From: Peter Cleveland [REDACTED]
Sent: 20 February 2019 16:47
To: Simon Davis <Simon.Davis@arun.gov.uk>
Subject: RE: AW/259/18/PL

In addition to the extension of time, I also need your agreement to the Pre-Commencement condition which Mark has proposed. This will read as follows:

Before the site is occupied or any machinery is introduced to the site or demolition work or construction work or alterations to existing ground levels takes place (but after agreed vegetation clearance) a PRE-COMMENCEMENT Site Meeting is to take place between the Arun DC Tree Officer and the Arboricultural Expert representing the site owners - at this meeting all protective fencing and ground protection measures will be inspected to verify they are 'Fit for Purpose' as required under British Standard 5837:2012 and have been erected and positioned exactly as shown on the Tree Protection Drawing, Dwg.no. RCo 241 / 02, Rev.02, dated 24th April 2018.

10 Barrack Lane, Bognor Regis - 'No Dig' Construction Typical Section

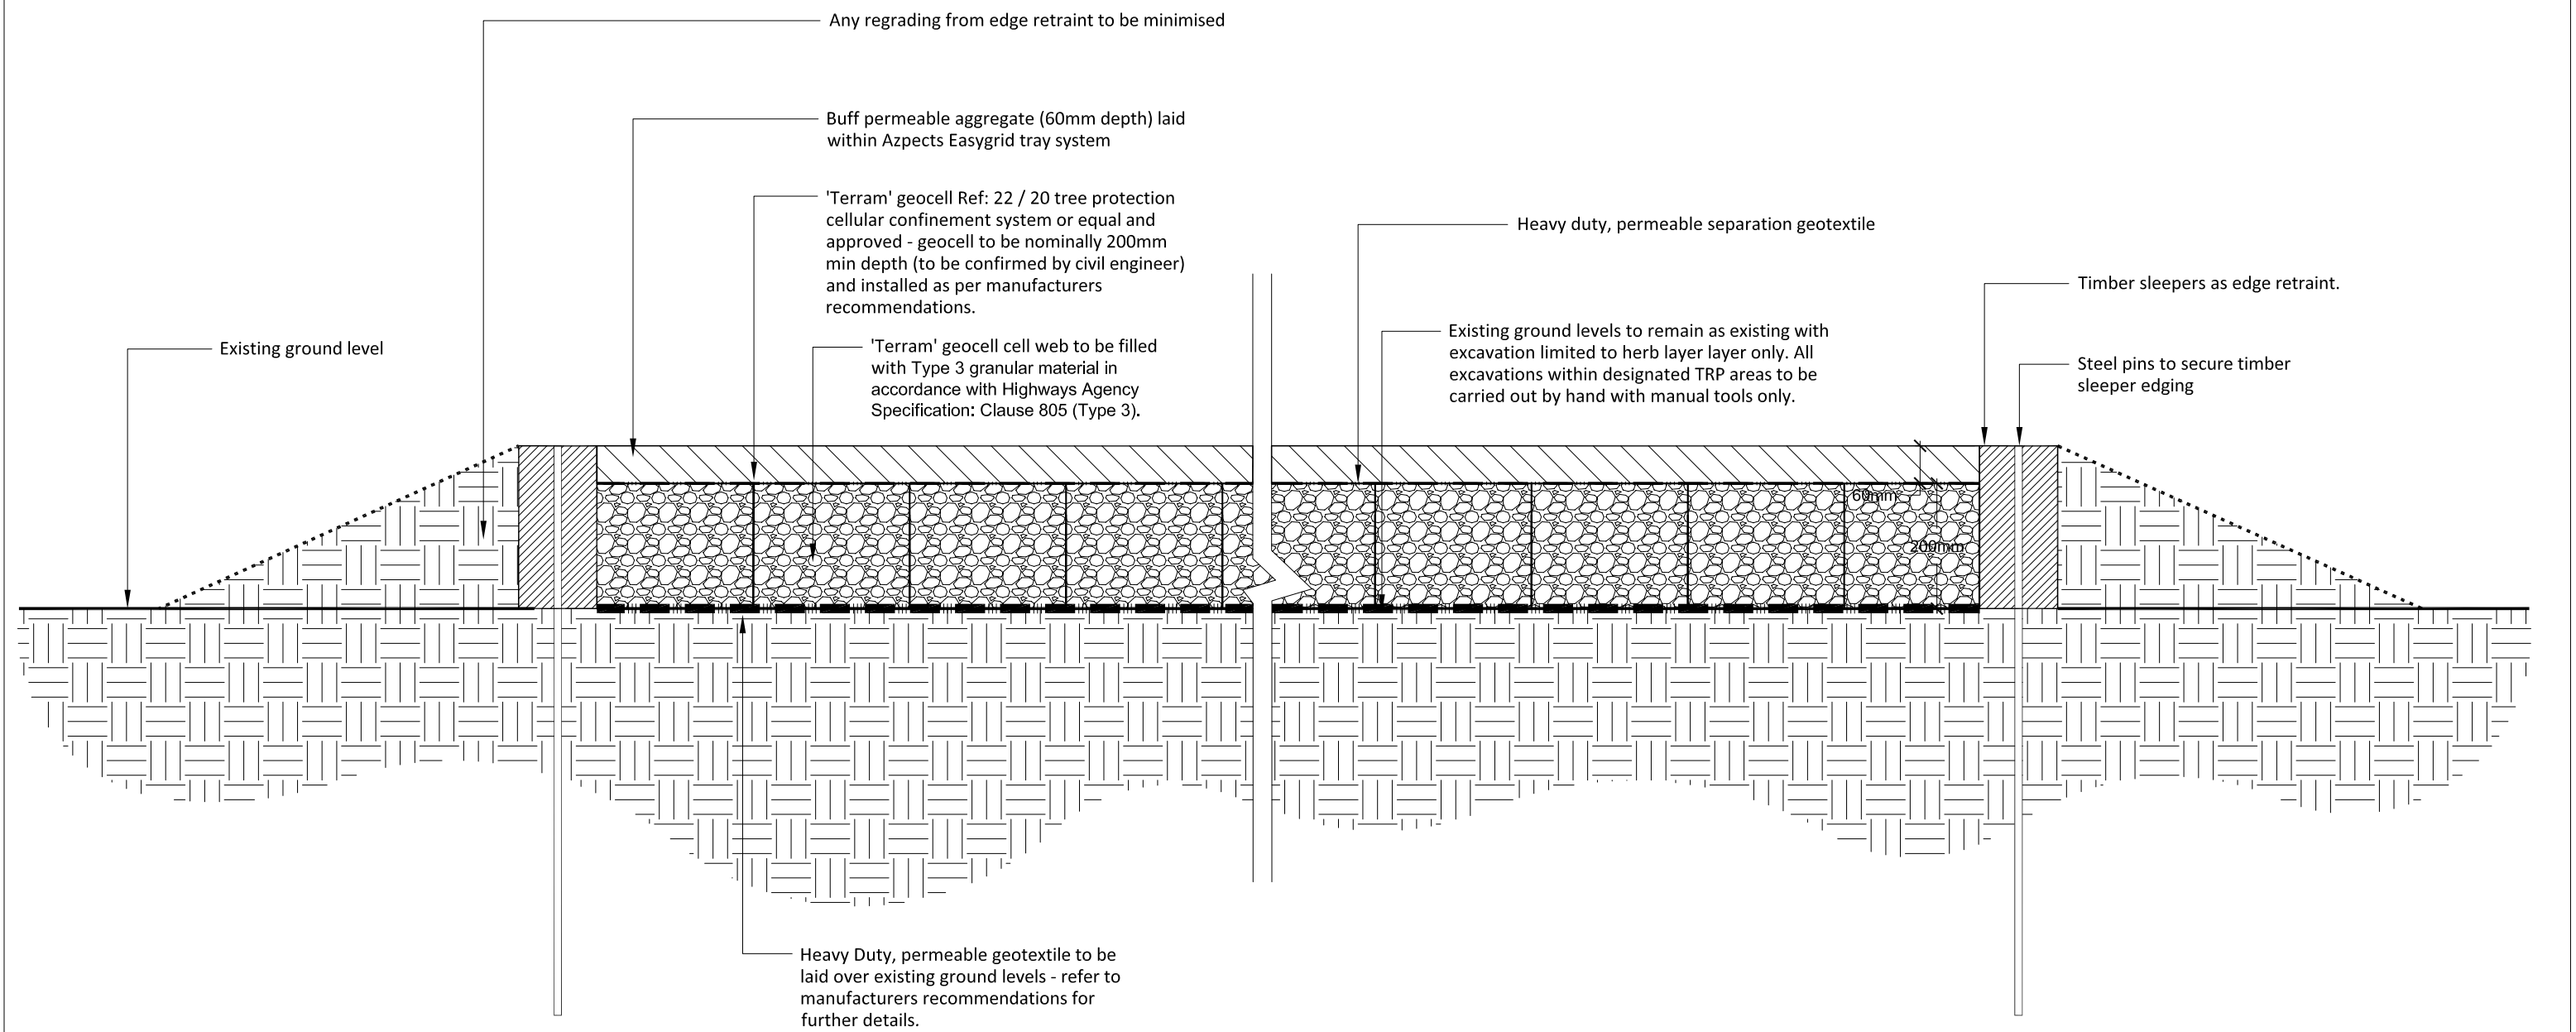
The No-dig construction must be as described and shown in the drawing No Dig Construction: Typical Section, dwg.no. RCo241/03, Rev.01, dated 22-01-19. Any significant deviation from this specification, especially with regard to the depth and manufacturer of the cellular confinement system must be submitted for prior approval by this authority.
